From: Mae Hawkins <maehawkins@wavecable.com>
Sent: Sunday, June 5, 2022 6:41 PM
To: kelly.bacon.cd@co.kittitas.wa.gov <kelly.bacon.cd@co.kittitas.wa.gov>; mark.cook@co.kittitas.wa.gov <mark.cook@co.kittitas.wa.gov>; josh.fredrickson@co.kittitas.wa.gov <josh.fredrickson@co.kittitas.wa.gov>
Subject: SEPA comments on the Determination of Non significance Kittitas County SEPA checklist (SE-22-00002).

It appears there are some discrepancies on the planning of this project.

Parcel #19162 Driveway Improvement Extents

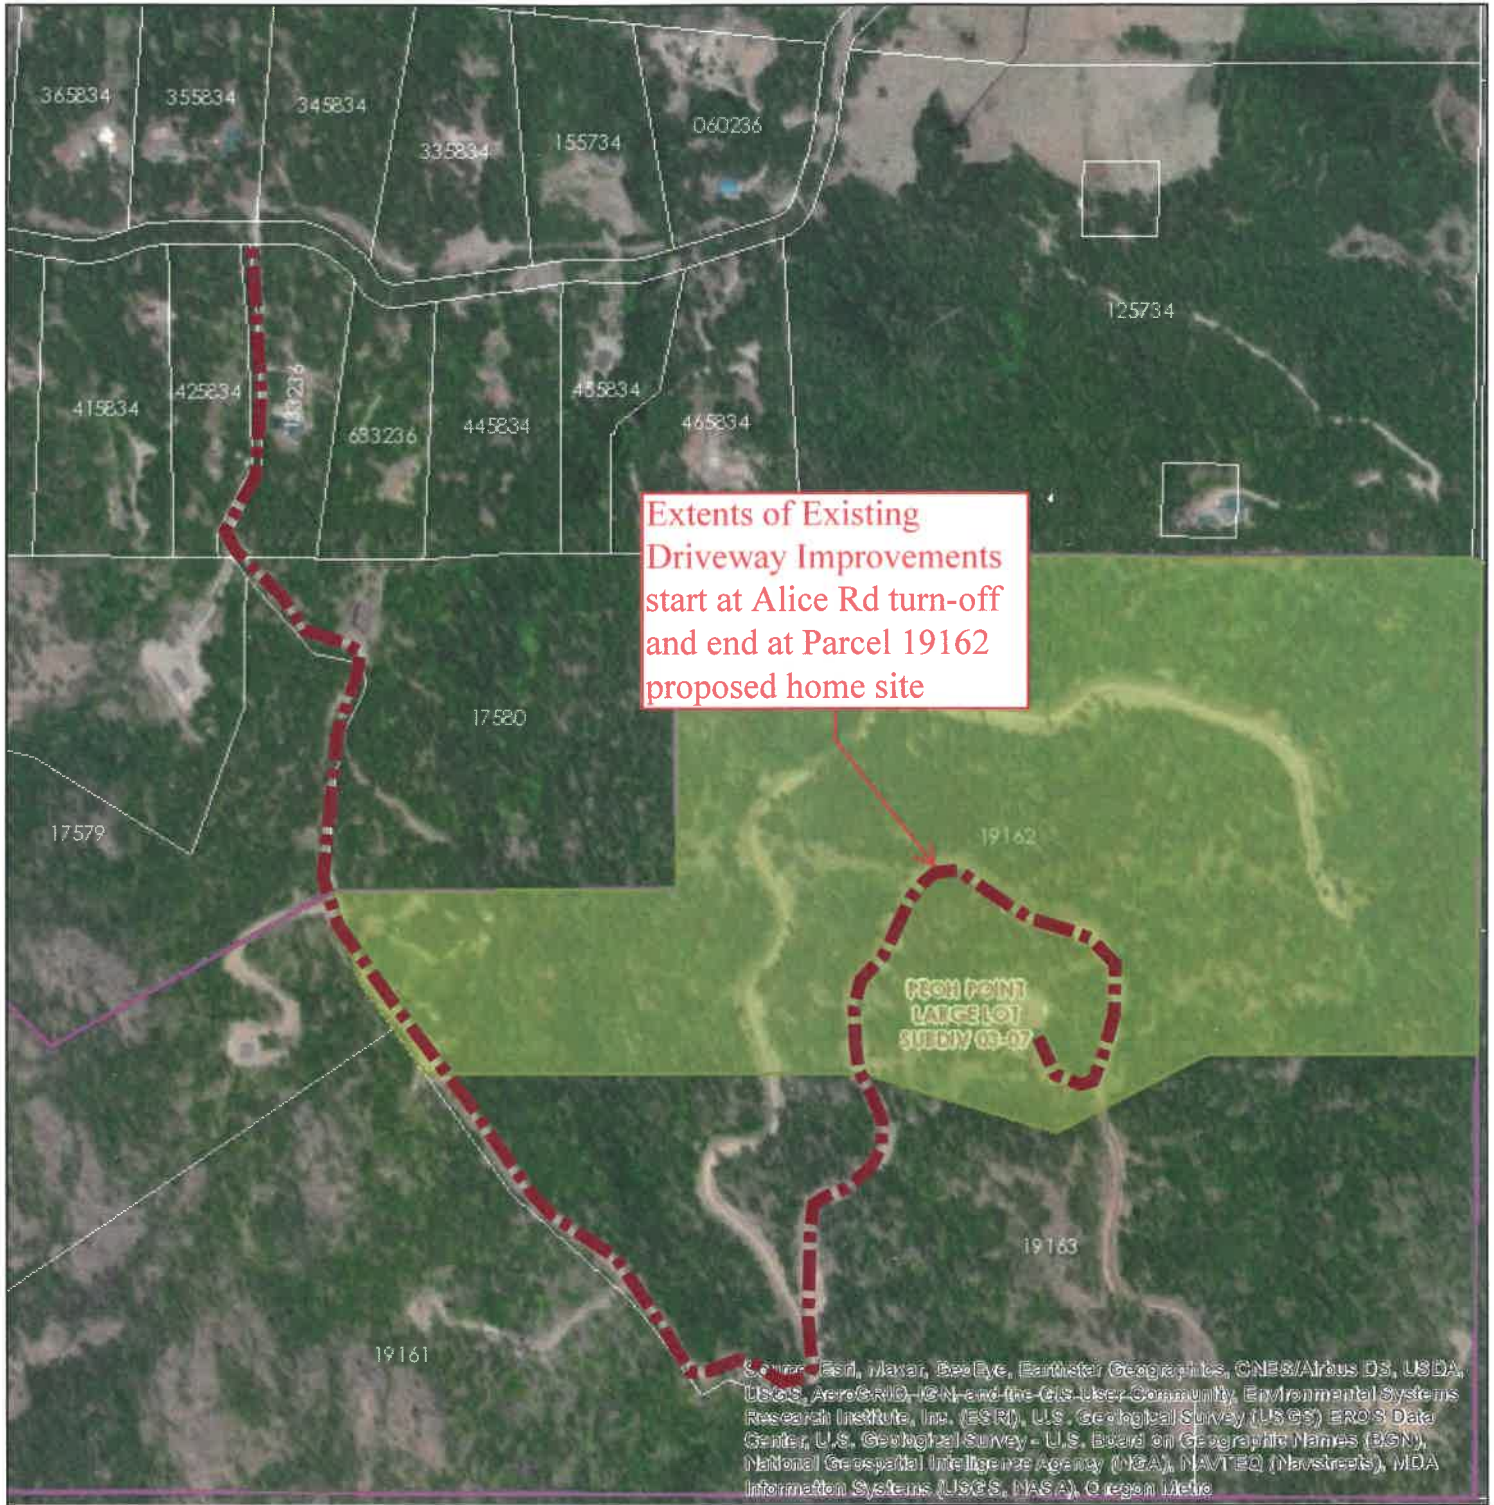
First, The SEPA checklist and project proposal did not properly identify or account for all of the parcels and users that are served by the access road. The access road serves 9 parcels, five of which already have addressed residences in place, and so is not a "driveway" as defined by the County codes. We are one of the nine and have concerns why this was overlooked. It seems that others who live or own property on Alice and the access road should have more input than one new buyer.

Second, the equipment during construction will more than likely damage the roads. I really feel for the year-round residents as this will be a huge inconvenience. I am also concerned while construction is going on will any of us be notified? Who is responsible for this? If we drive 2 hours to get there and can't access our property due to road construction, we would not be happy campers!

In closing, I believe the County should withdraw the DNS based on insufficient information from the applicant regarding an accurate accounting of the parcels being served by the access road, and the full project scope as it impacts Alice Road. Also request that any determination should include mitigating conditions that will ensure that Alice Road is not damaged and that the applicant would be solely responsible for any improvements or conditions that the County may require.
